ROCKY TOP RESOURCES

SITE DEVELOPMENT PLAN

1755 E. LAS VEGAS STREET, COLORADO SPRINGS, EL PASO COUNTY, COLORADO

SITE DEVELOPMENT PLAN

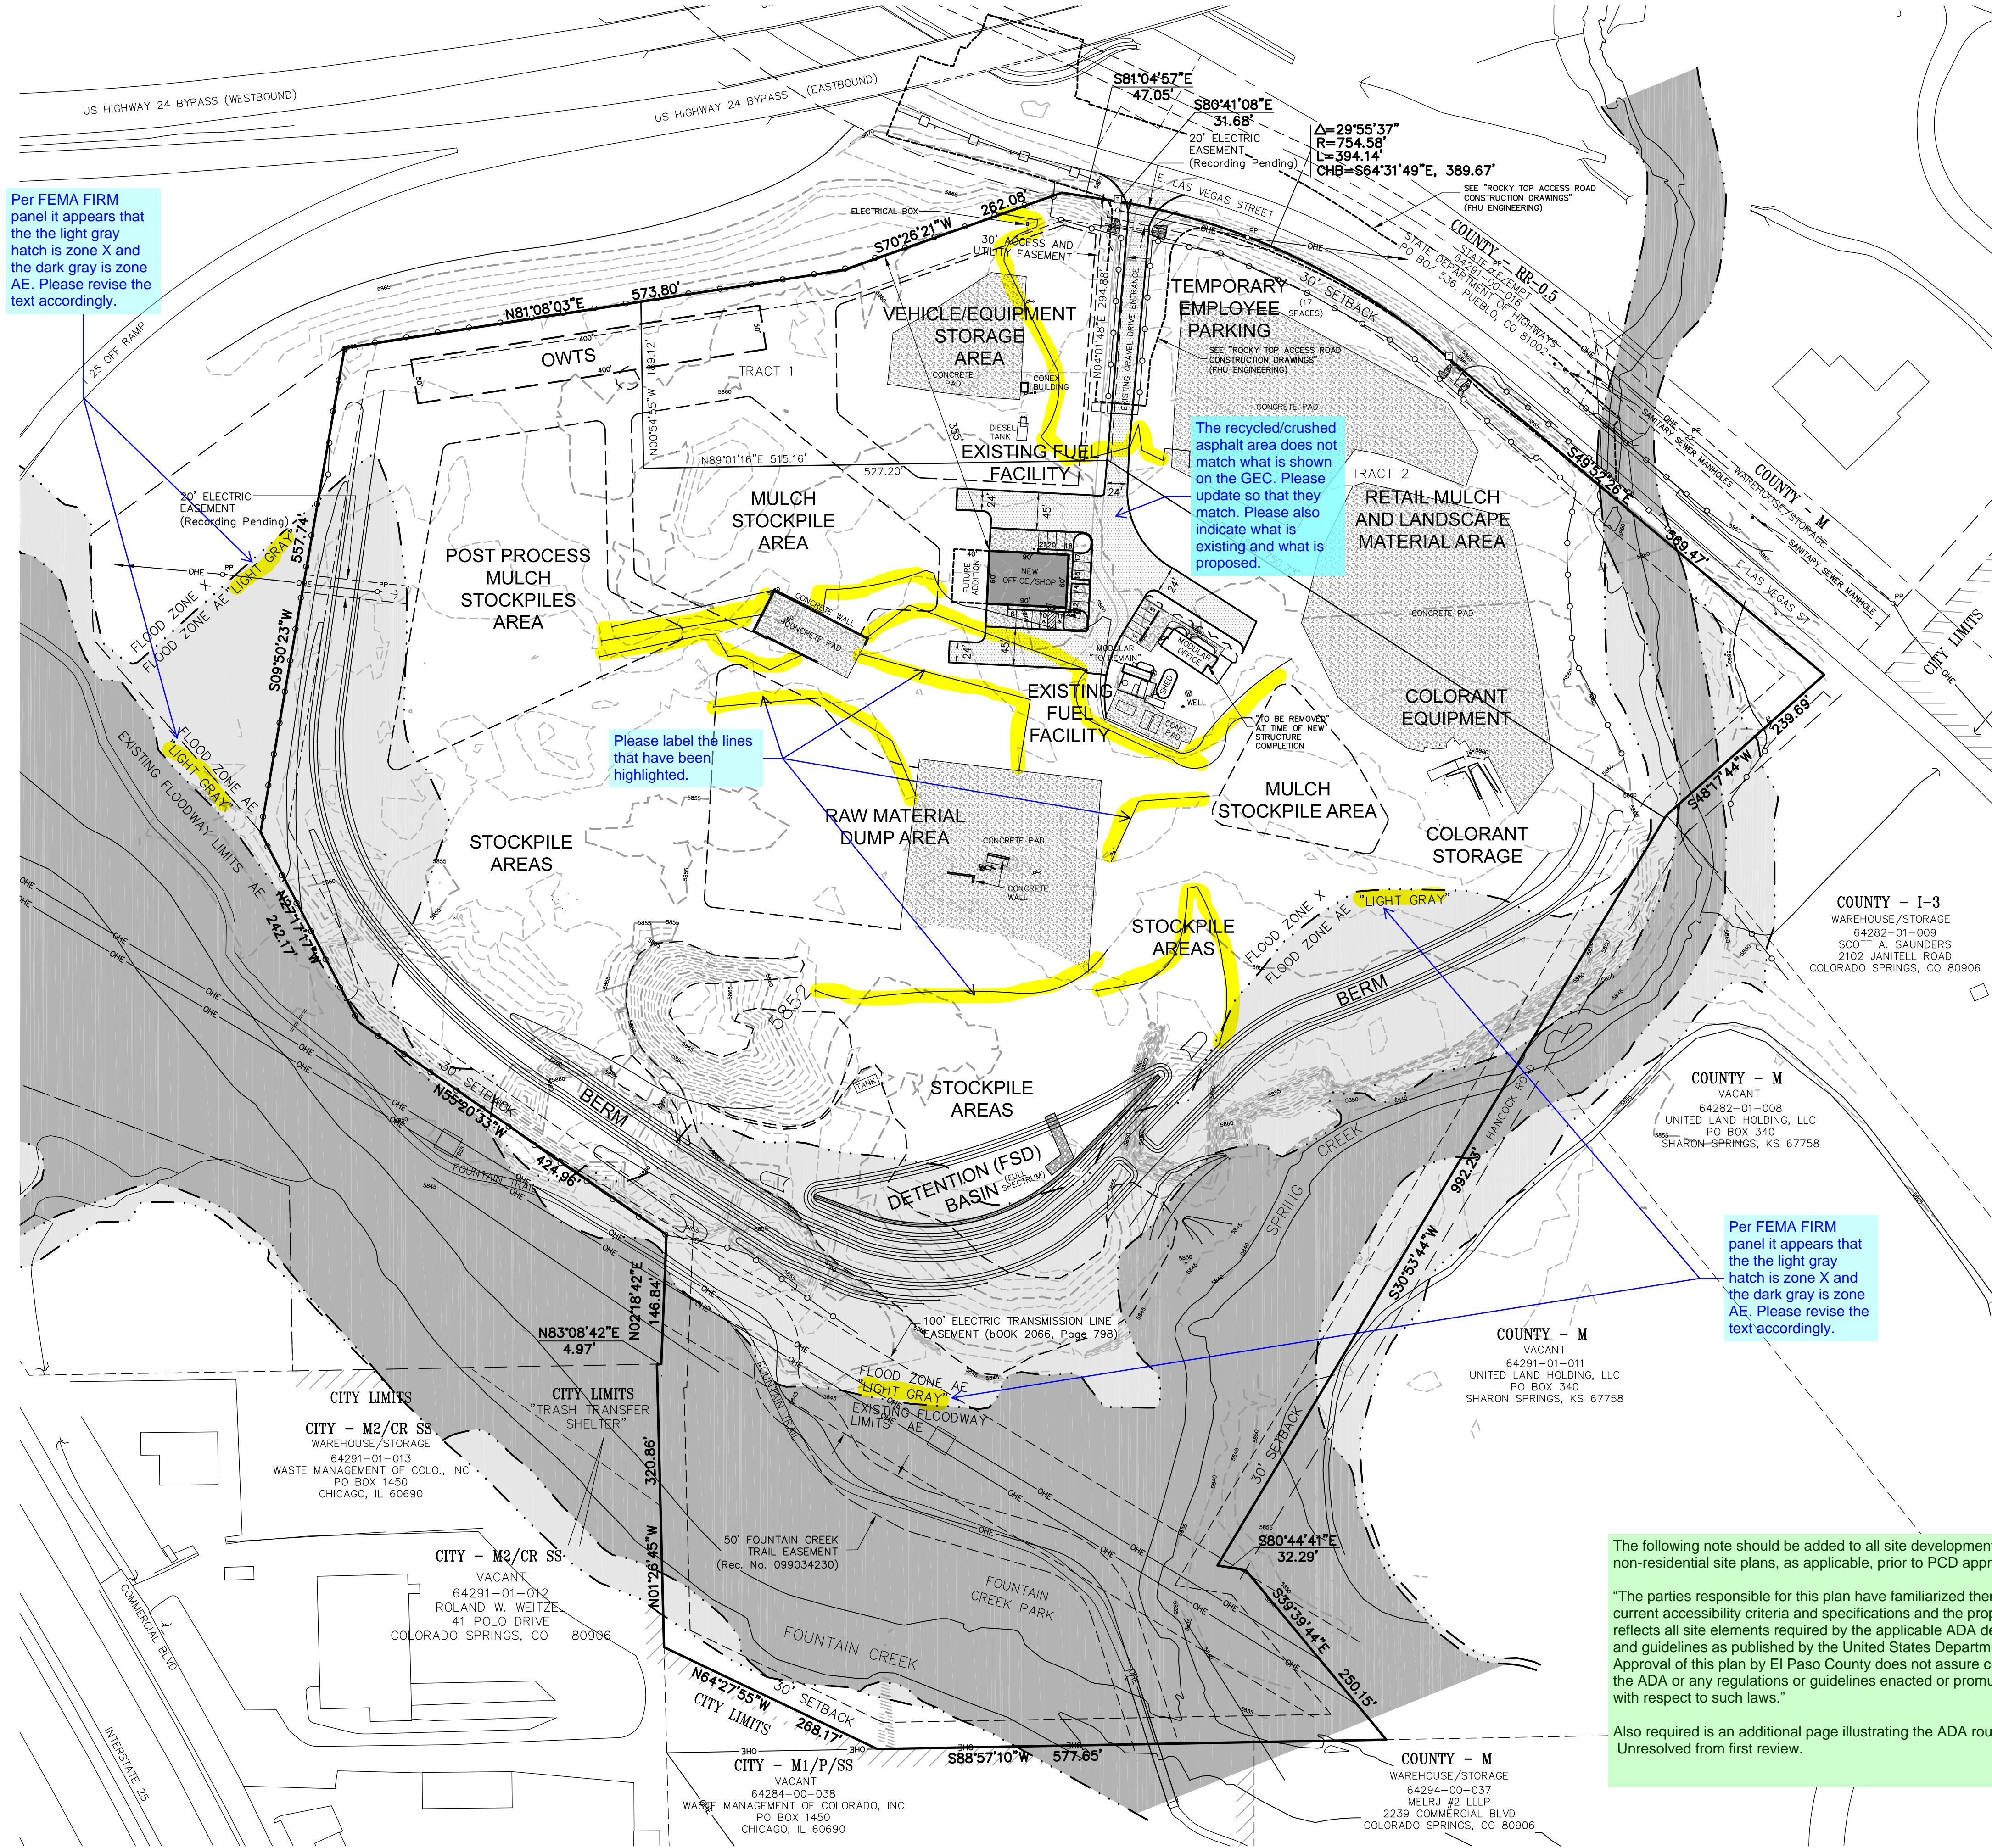
The following note should be added to all site development plans or non-residential site plans, as applicable, prior to PCD approval:

"The parties responsible for this plan have familiarized themselves with all current accessibility criteria and specifications and the proposed plan reflects all site elements required by the applicable ADA design standards and guidelines as published by the United States Department of Justice. Approval of this plan by El Paso County does not assure compliance with the ADA or any regulations or guidelines enacted or promulgated under or with respect to such laws."

Also required is an additional page illustrating the ADA route.

Is this the OWTS area? If it is please fix abbreviation, if it is not please label this area.

The extent of all the areas, vehicle/equipment storage, raw material dump areas, etc, need to be shown on the Site Development plan. Stating the whole area is not applicable for the standards to be met.

Show the ingress/egress easement

Need details of Fuel Facility and Letter from Fire Department approving design of Fuel Facility

Identify this hatch pattern. I believe this is asphalt.

Label what these are, or provide a description

Indicate the height of the concrete walls. Any wall 2 foot or taller is considered a structure and requires a building permit.

Show the proposed FSD pond

update firm panel

Show the 100-year and 500-year floodplain boundaries
